Subject: Fwd: Planning Application EP/157/19/HH St Briac ,South Strand,East Preston Bn16 1 NY

> "Of particular concern was the proposal to use grey Marley Cedar board and 'coloured render' for the walls. The Committee was concerned the resulting property would look unnecessarily monochrome, contrary to the vernacular palette of the area."

Project: Proposed extension; St. Briac, South Strand, East Preston BN16 1NY	
Drawing: Elevations as proposed	
For: Mr. J. Trusson & Ms. L. Byrne	
Drawn: PKS	Date: November 2019
Scales: 1:100	No: 2510/01/03
To scale when printed on A3

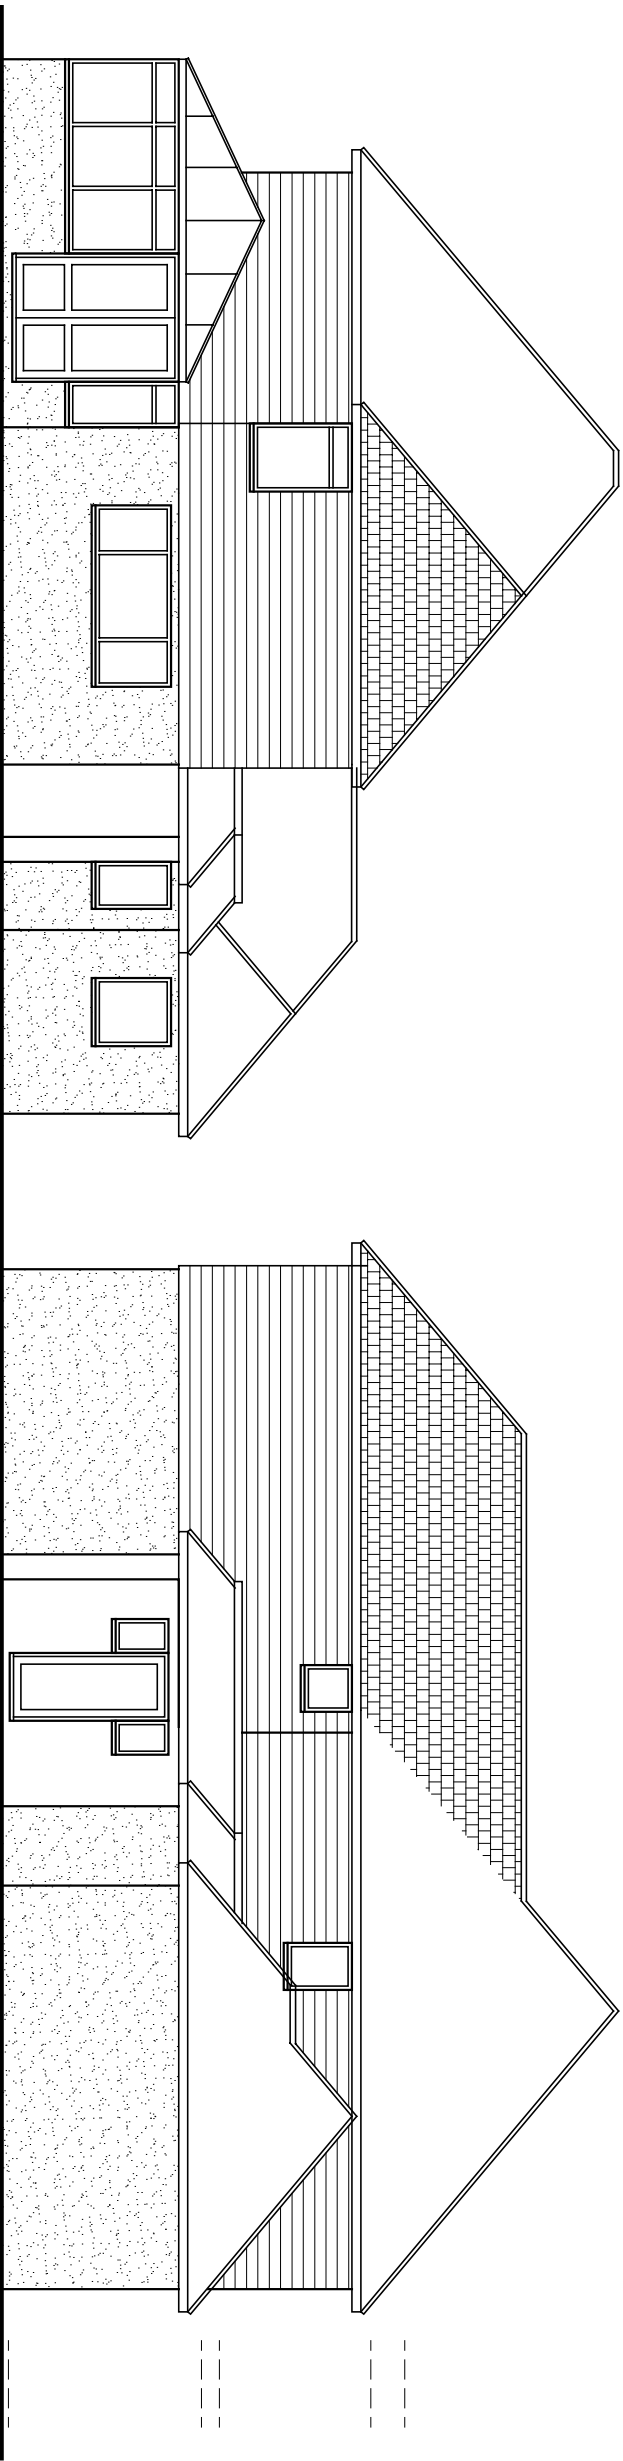
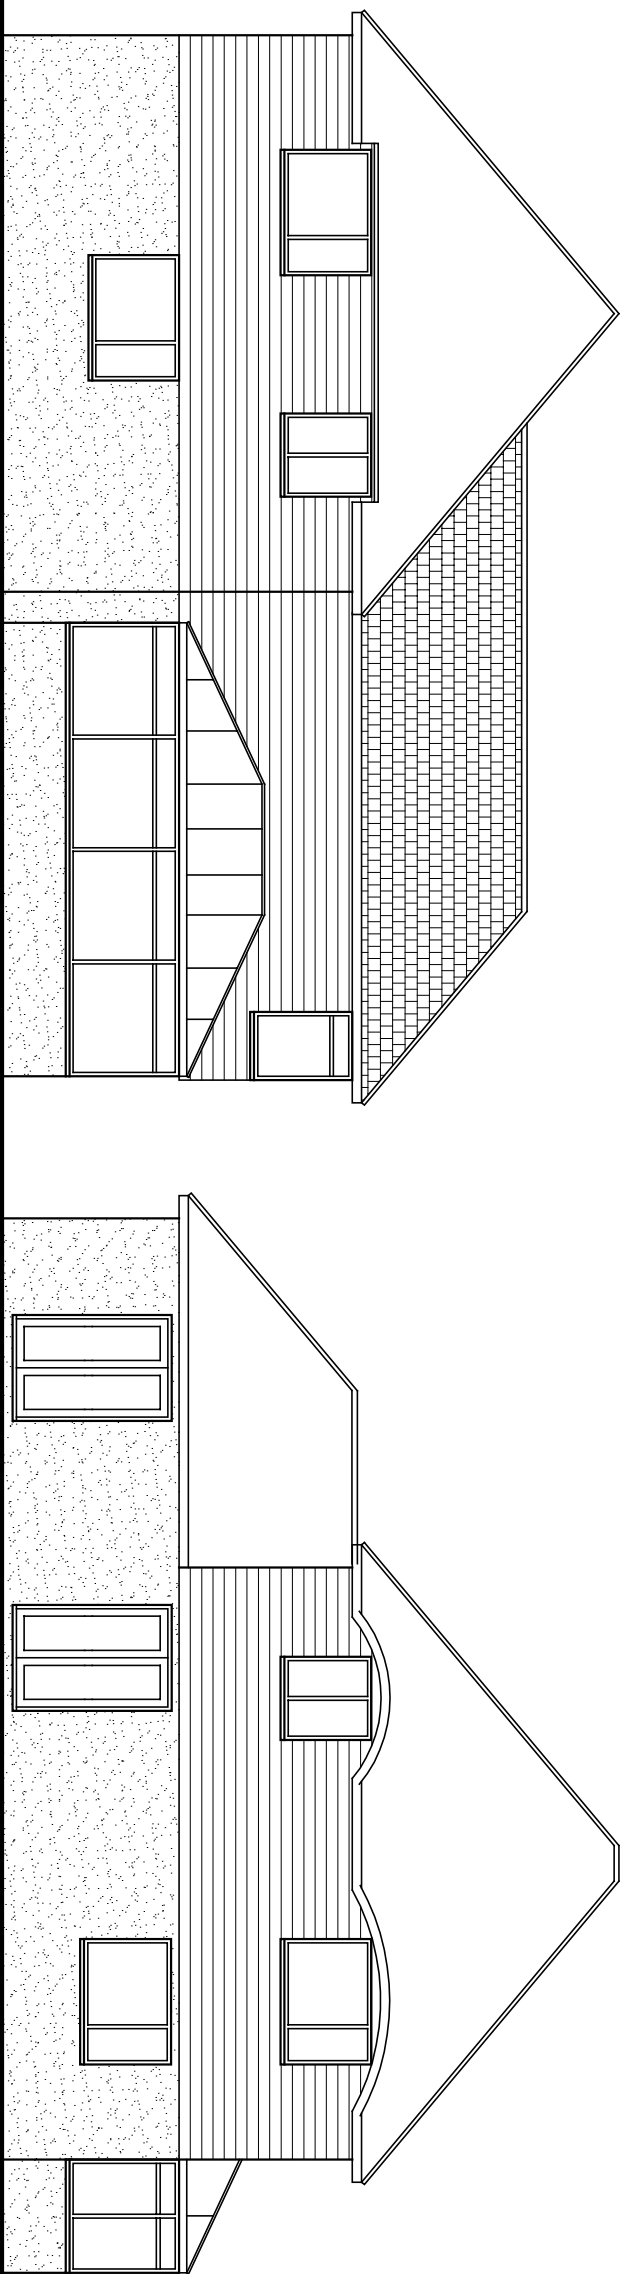
> The relevant EPPC minutes for December 23 2019 , which led to the internet comments , objected to " ...the proposed materials, particularly the grey Cedar cladding, as these would not harmonise with neighbouring properties." The Committee Agreed it would support the Preservation Society's objections to the cladding but ,crucially ,NOT to the extension.

> My plans actually alleviate this problem as The “coloured render “ on the lower half of the house will not be grey , it will match the existing garage (visible from the road) that can be best described as” off white/cream”. I believe this overcomes the “unnecessarily monochrome “ objection.
